**KIRKLEES METROPOLITAN COUNCIL
INVESTMENT & REGENERATION SERVICE**

DELEGATED DECISION TO DETERMINE PLANNING APPLICATIONS

Reference No: 2021/62/92974/E

Site Address: 6, Wellhouse Close, Mirfield, WF14 0BQ

Client		Mr & Mrs Beal	
Job		6 Wellhouse Close Mirfield	
Title		Proposed Floor Plans	
Drawn By	RK	Date	July 2021
Eng. Check		Scale	1:50 /100
Tech. Check			
Drawing No.		Rev.	
2021 / 322 / 05

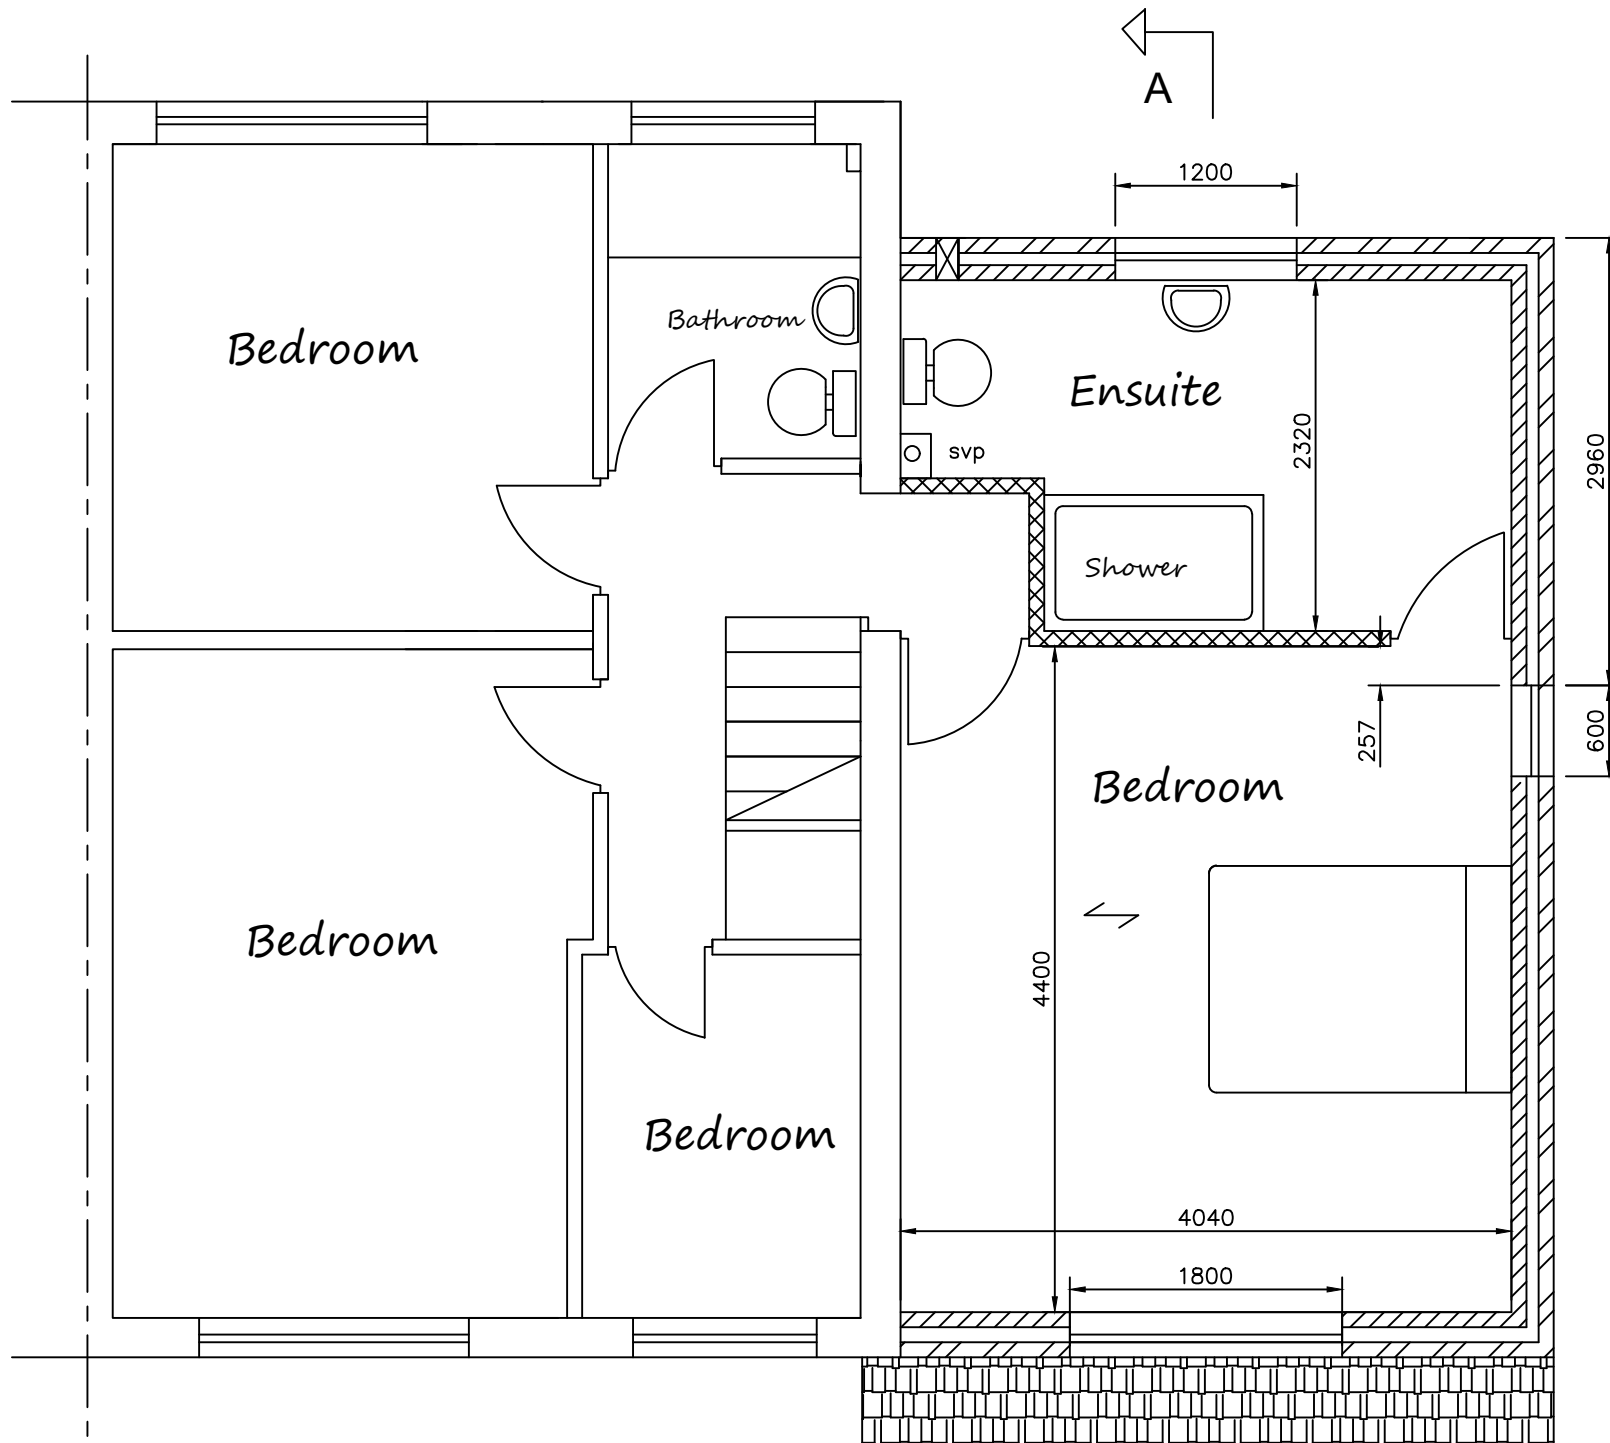
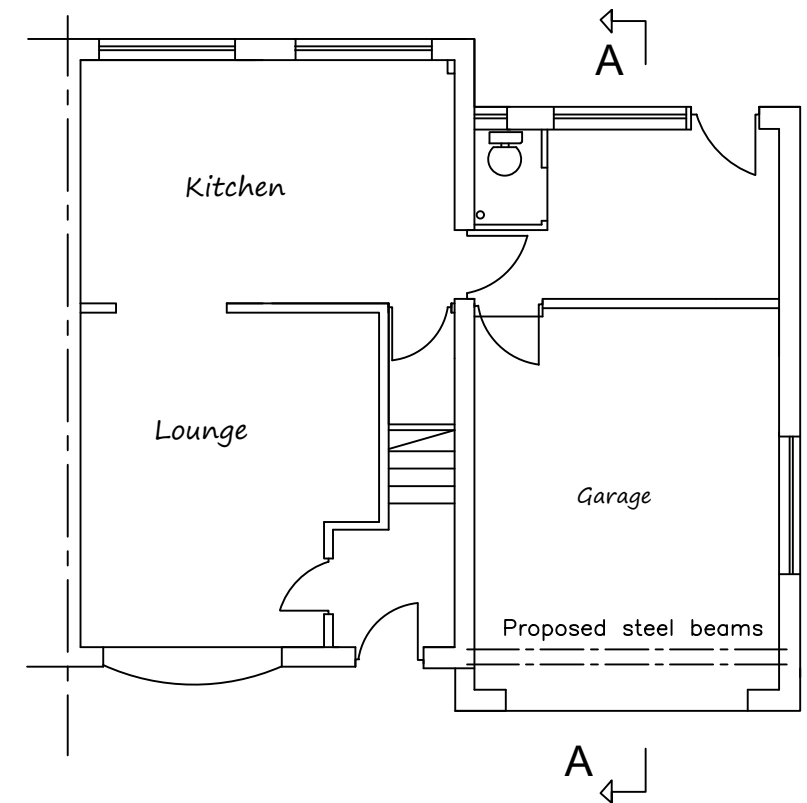
Officers were concerned regarding the subservience of the proposed extension and the lack of compliance with the SPD. Amendments were sought and provided with a 0.5 metre set back and therefore a reduction in roof height, Amendments were considered acceptable. The description of proposal was amended to include the lean-to roof over the existing garage.

Amendments were sought and provided with a 0.5 metre set back and a reduction in roof height. Amendments were considered acceptable. The description of proposal was amended to include the lean-to roof over the existing garage.
